Rezoning Transportation Analysis

Petition Number: 2020-133

Date	Description
10/20/2020	First Review (KP)
11-30-2020	Second Review (KP)

Conceptual Site Plan

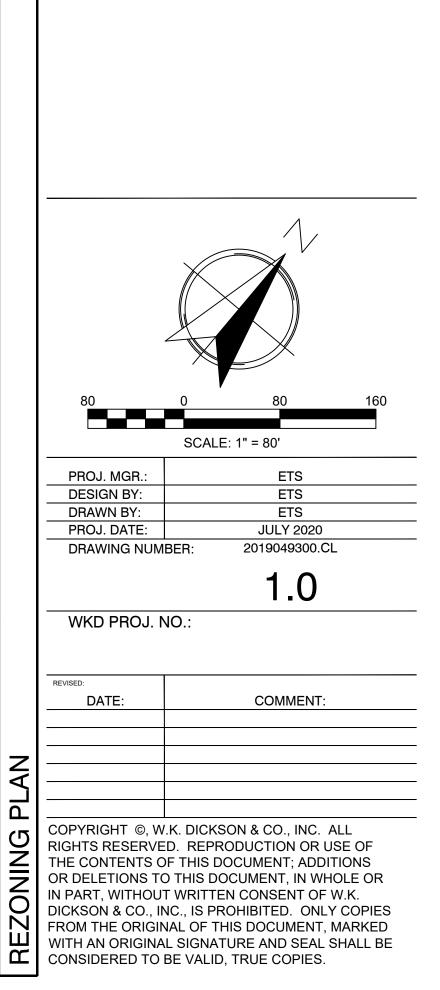
- Label and dimension the curb line, as depicted on the site plan, from the centerline of Hamilton Road to the proposed back of curb.
Update to Comment as a result of the 11-16-2020 Site Plan: The curb line needs to be clearly labeled and dimensioned from the existing center line of Hamilton Road

- Label and dimension the proposed right-of-way, along Hamilton Road, from the Hamilton Road centerline, including the commitment to dedicate the proposed right-of-way in the conditional notes.
Update to Comment as a result of the 11-16-2020 Site Plan: The proposed dedicated ROW needs to be clearly labeled and dimensioned from the existing center line of Hamilton Road

- Label and dimension the proposed planting strip and the 12-foot multi-use path from the centerline of Hamilton Road, including the commitment to the construction of the proposed planting strip and 12-foot multi-use path in the conditional notes.
Update to Comment as a result of the 11-16-2020 Site Plan: The planting strip and MUP need to be clearly labeled and dimensioned from the existing center line of Hamilton Road
